PLANNING APPLICATION: FP/140/13/T

ADDRESS: 29 Links Avenue Felpham PO22 7BL

BRIEF DESCRIPTION: Re-pollard at 6 metres above ground level, removing 9 meters of crown above pollard to 2 No Common Lime trees.

T1 - SMALL-LEAFED LIME  
- RE-POLLARD

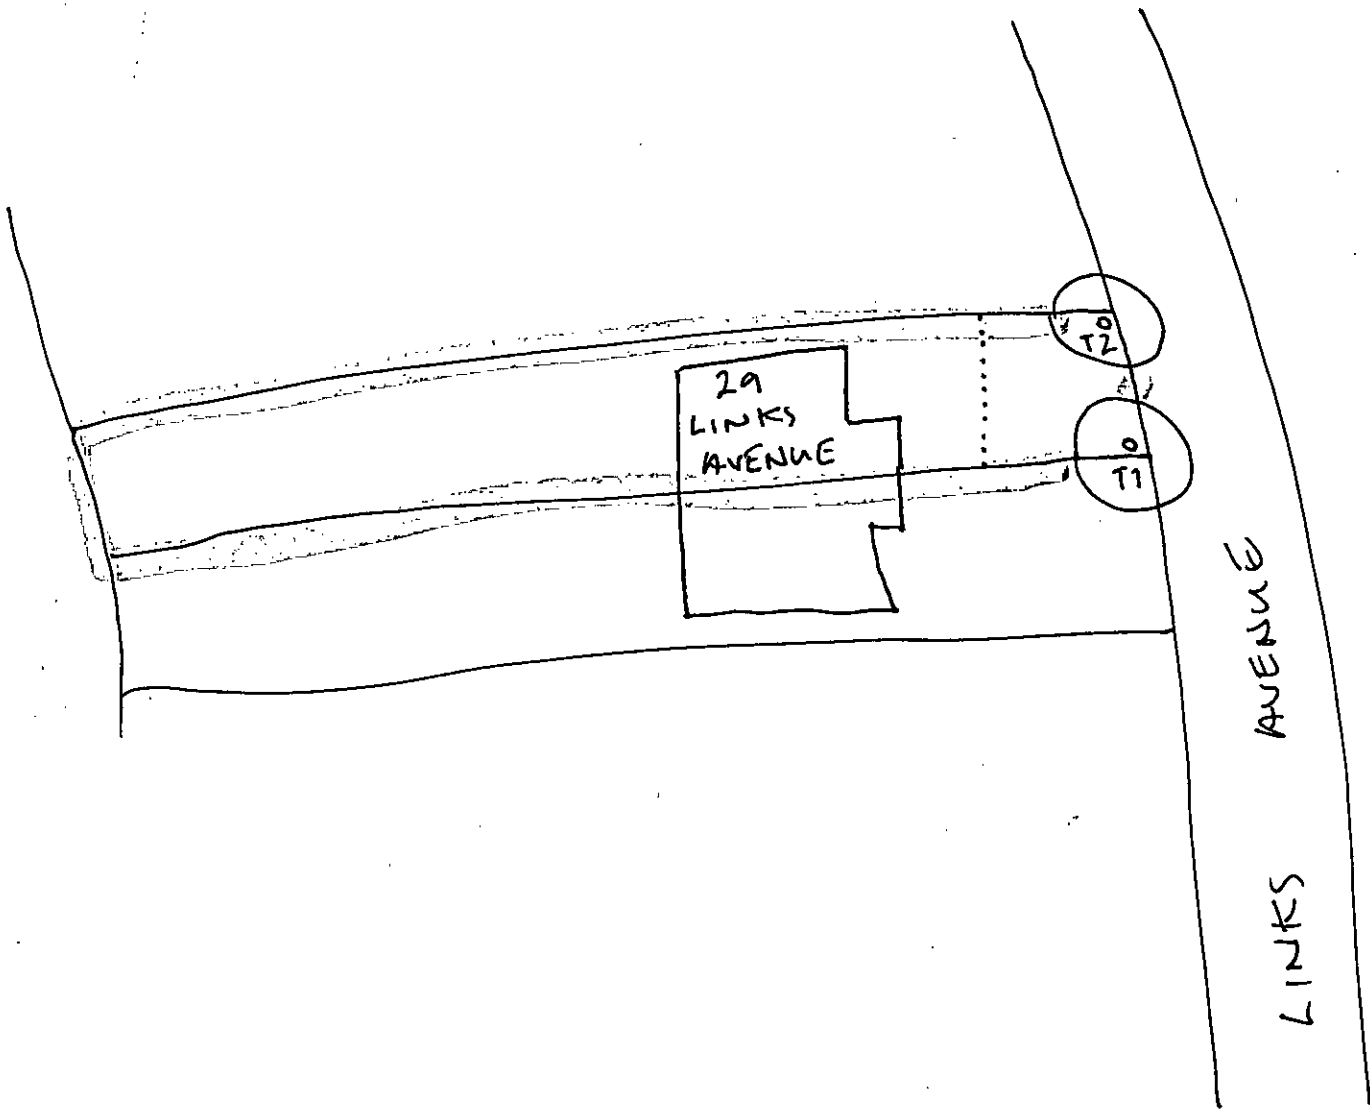
I did not detect the presence of fungi at either tree's basal areas. However there was evident a juvenile developing *Ganoderma* fungi bracket. This is a parasitic organism and will destroy live supportive wood tissues. The fungi is emerging below the heavily decaying cavity of the main branching stem located at 3m from the ground of (T1) the Small Leaf Lime tree. This is a concern as it increases the likelihood of stem failure within a shorter period of time. The recommendation to reduce the tree to a 6m standing main stem height in accordance with the consultant's report is therefore acceptable.

The loss of T1's crown would expose the unevenness of T2 the Common Lime. Although there is a need to carrying formative pruning to T2, the cutting down to a similar height of a 6m high main stem is not recommended. It is preferably to retain the presence of tree height by recommending reduction of the crown by 5m to stimulate the production of an even and balance crown from an otherwise asymmetric shape.

T1 as per tree consultant's recommendations cut to leave main stem height of 6m

T2 Reduce Crown by 5m, this should be carried out mainly from the North West with little to be pruned adjacent to T1. Wound sizes to be kept small restricting their diameter to 150mm or less.

The tree work to T1 is necessary to abate a danger where a 5 days' notice to carry out the work is acceptable. If the crown reduction of T2 is unacceptable then the application for this work should be refused consent.
